Planning Application Ref: A/40/18/OUT

Location: Land North of Water Lane, Angmering

Description of works: Outline application with some matters reserved for the development of up to 525 residential dwellings (Class C3), 3 ha (gross) of employment land (Class B1), public open space, play areas, access, associated infrastructure and landscaping.

Tree Officer / Parks and Greenspace Team

PROPOSED ACCESS FROM DAPPERS LANE

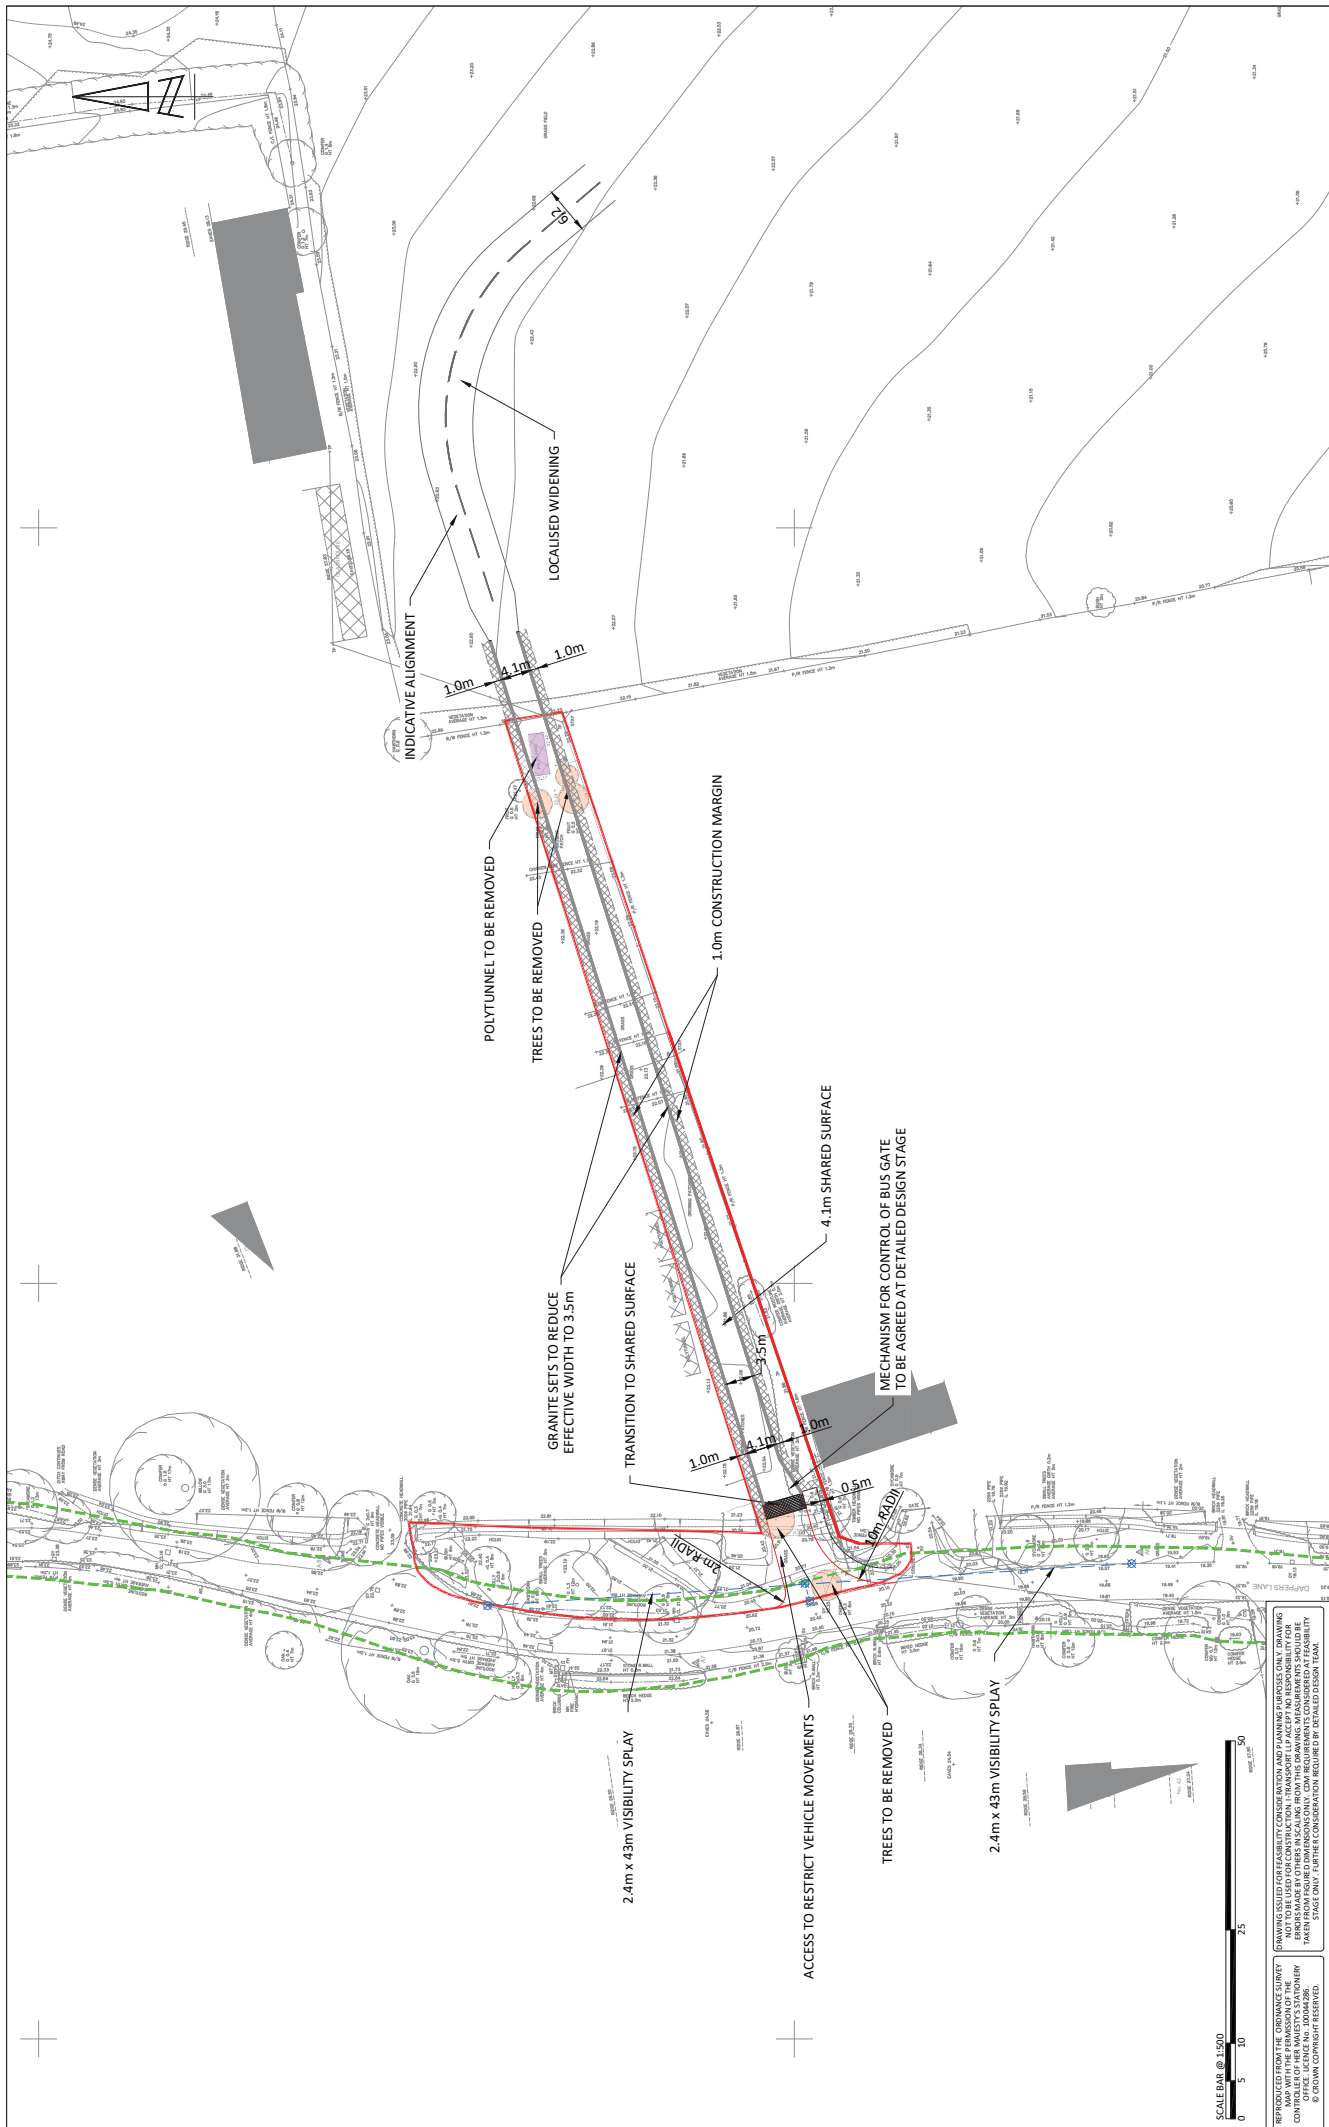
- The proposed foot/cycleway link out onto Dappers Lane would impact heavily on large landscape trees, such that their removal may be required to facilitate this element of the scheme. The footway/cycle route should emerge north of the existing path and beyond the RPAs of the two mature (off-site?) roadside oak. These are long-established trees on woodland periphery and of high ecological/visual amenity value.

- Re-routing of foot/cycleway link out onto Dappers Lane that fully respects the RPA of mature roadside oak trees (not shown on TCP or TRP).
- Revise plot configuration to fully respect RPA (radius 15m) of T24 and exclude from garden/recreation areas.
- Clarify and demonstrate on plan a 15m buffer zone from the crown periphery of ancient woodland (Grooms Copse).
- There is insufficient detail at this stage to guarantee that significant trees will be retained and afforded the necessary level of respect and protection to ensure their ongoing health and vitality. No Tree Protection Plan or detailed Arboricultural Method Statement (where RPA incursion is unavoidable) has been provided, although I would expect those to be submitted at full application stage.

Tree Constraints Plan

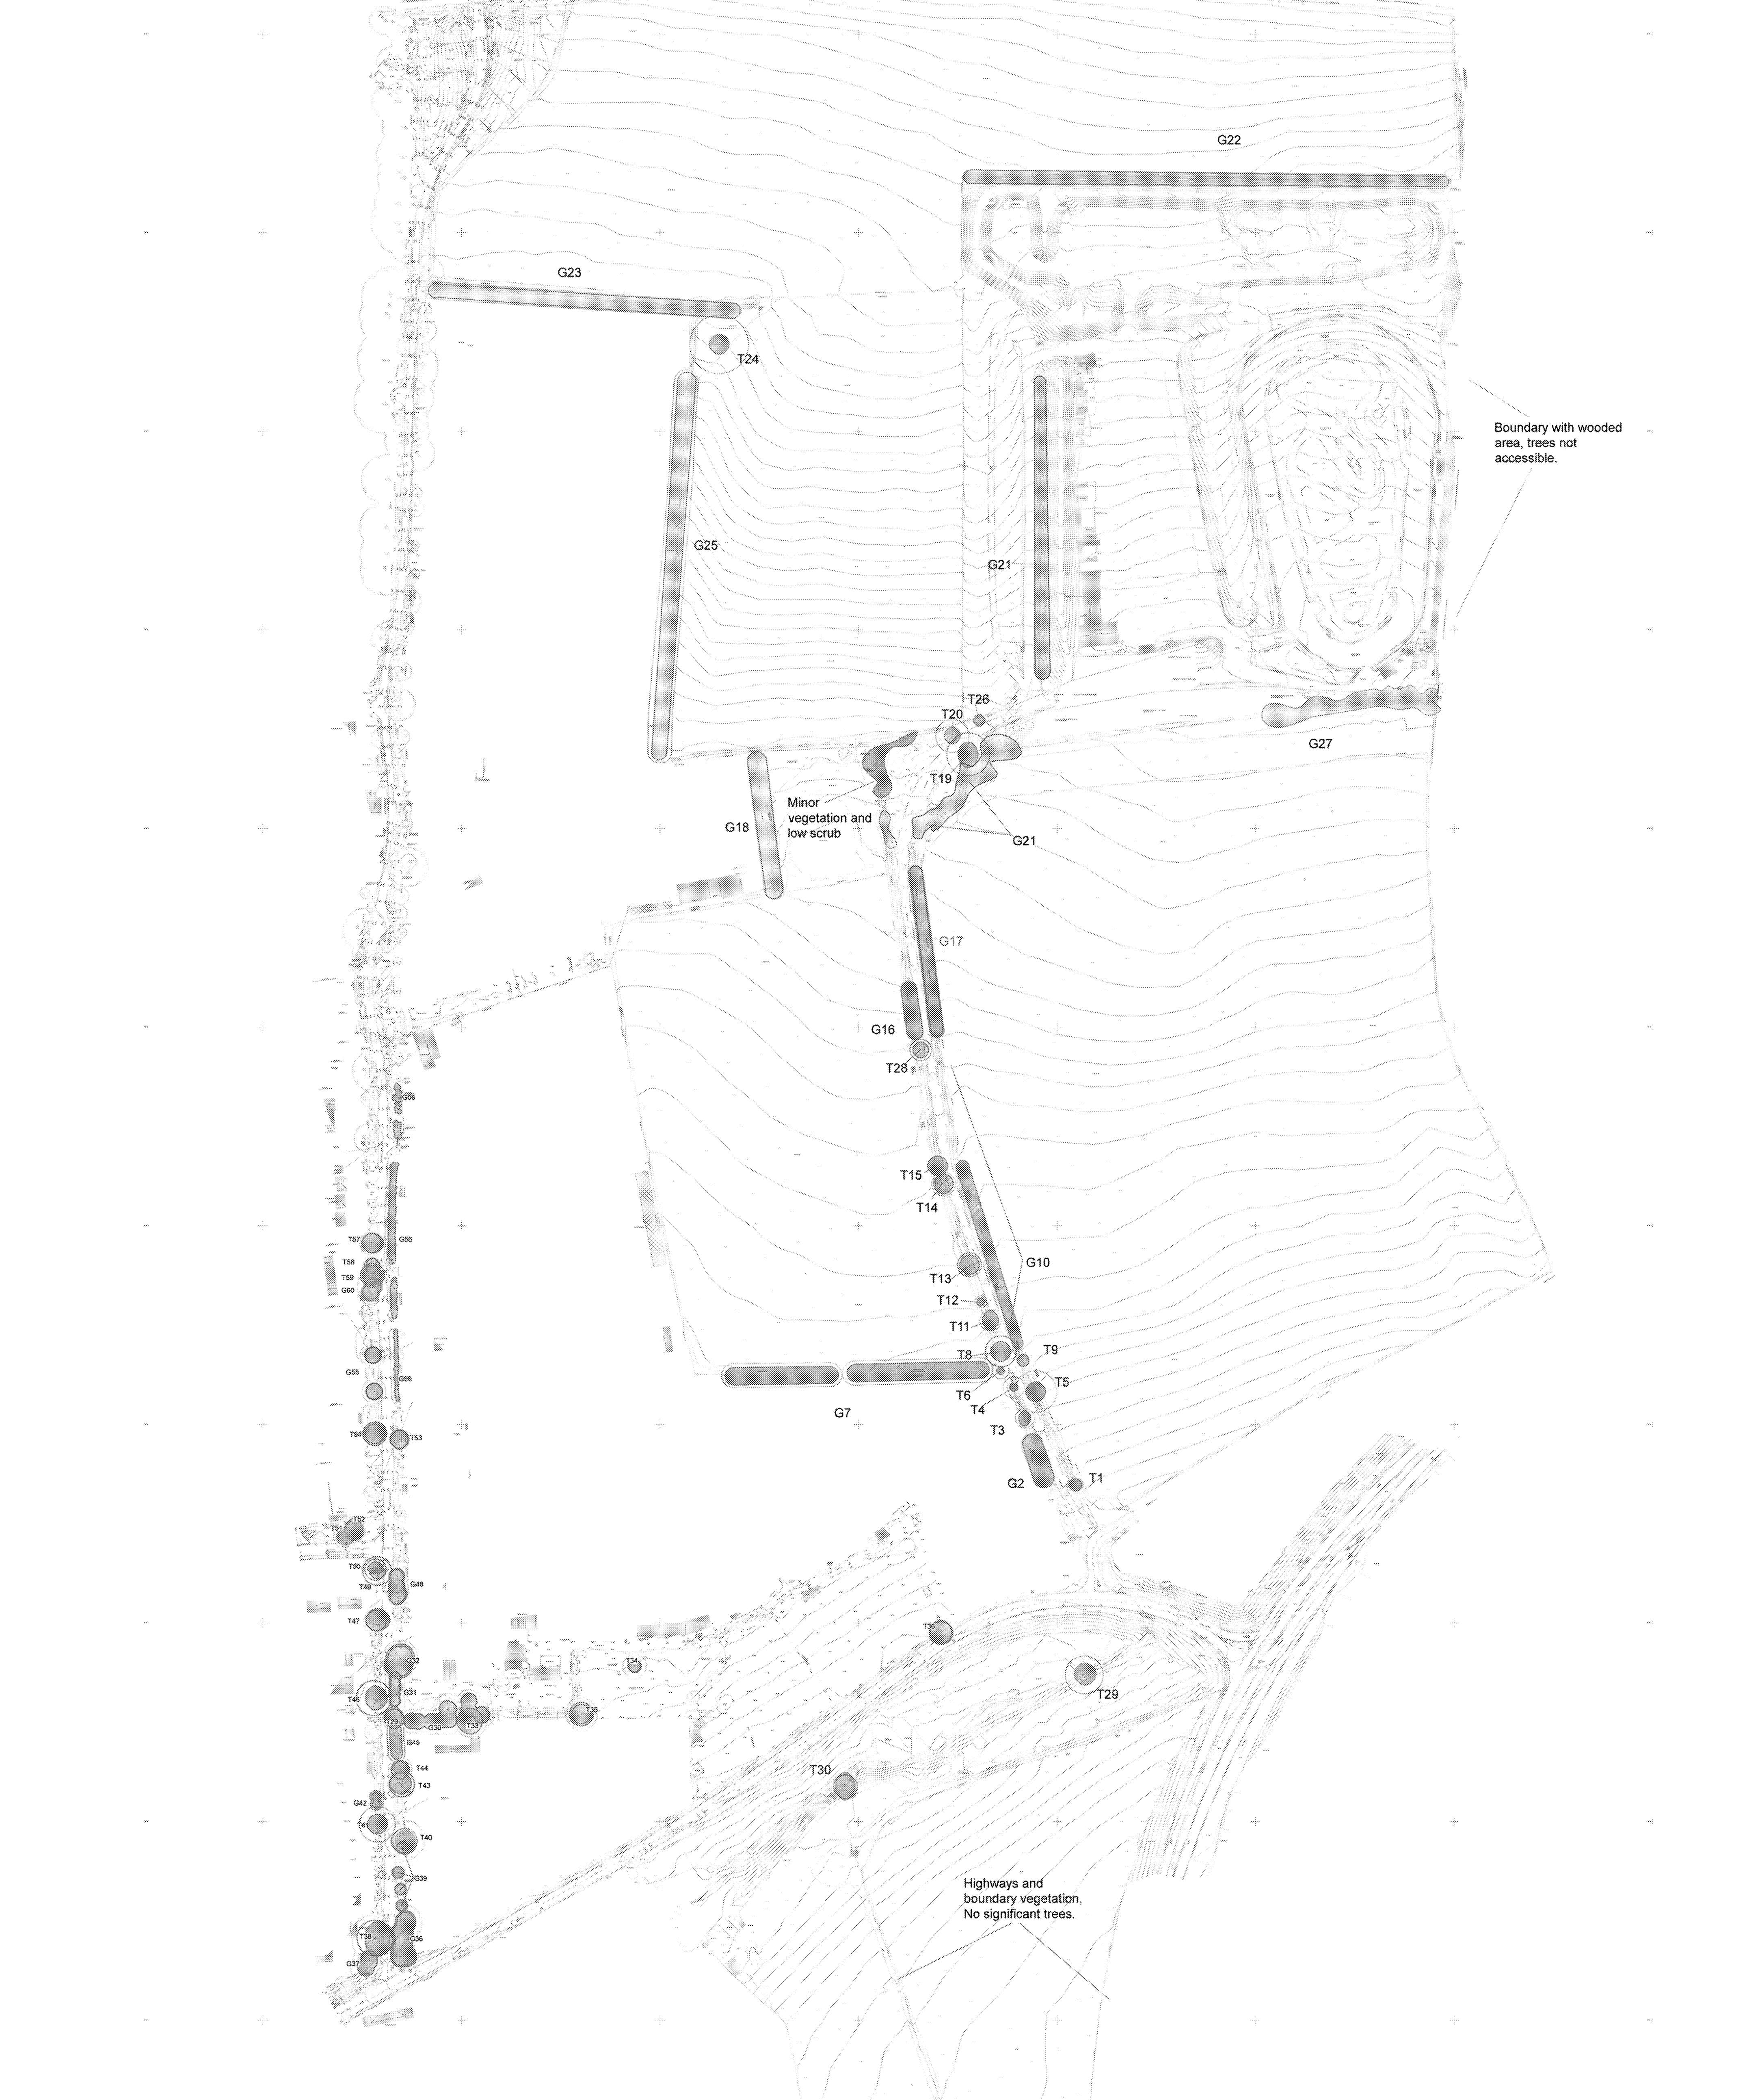
- The applicants employed the PJC Consultancy to undertake a tree survey and then prepare an Arboricultural Impact Assessment (AIA), ref.4652/17-02 Rev-07, dated 02-Feb-2018, inclusive of Tree Survey Schedule, Tree Constraints Plan (TCP) and Tree Retention Plan (TRP). Tree Survey data is comprehensive and accords with the requirements of BS5837:2012, although there are some notable elements with which I disagree. Stem diameter (dbh) readings are adequate - which is important for subsequent root protection area (RPA) calculation/display, but *tree height/spread* and more importantly *retention categories* have often been underrated/downgraded respectively.
